From: Sian Eggington [REDACTED]
Sent: 19 August 2019 15:38
To: Sian Eggington
Subject: FW: Further Information Required on Your Ref: PP-08074685 Our Ref: R/194/19/HH
Attachments: We sent you safe versions of your files; 532 - 07A Site + Block Plan.pdf; P1300936.JPG

Please find attached a revised block plan on which I have confirmed the width of the crossover.

Site and Block Plan Plan.
 Ref: SBS/532/07 A

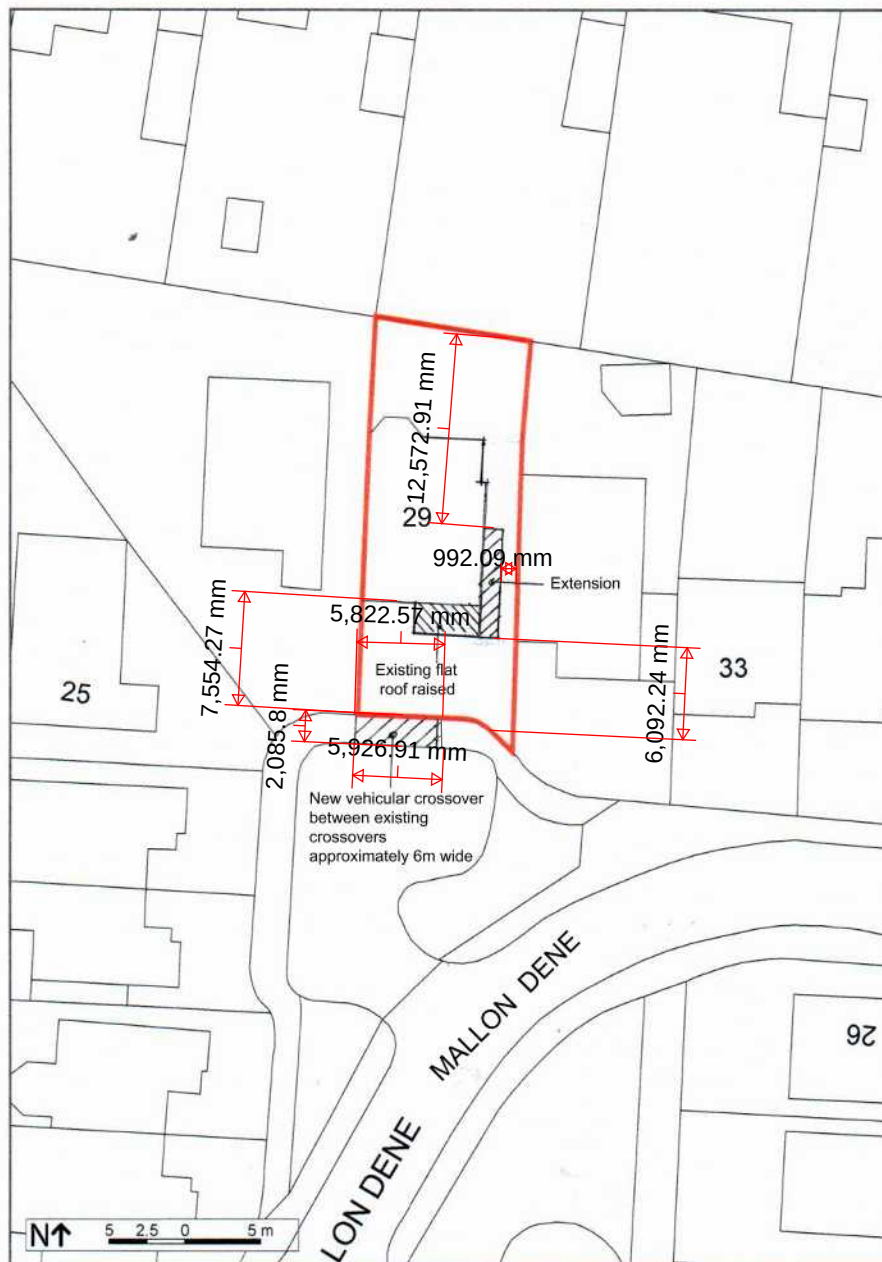
The crossover exits onto a very small cul de sac used for parking and not a road. There is no carriageway to the right other than about 1m of the neighbour's driveway (see block and location plan together with attached photo) so the visibility splay requested cannot be provided.
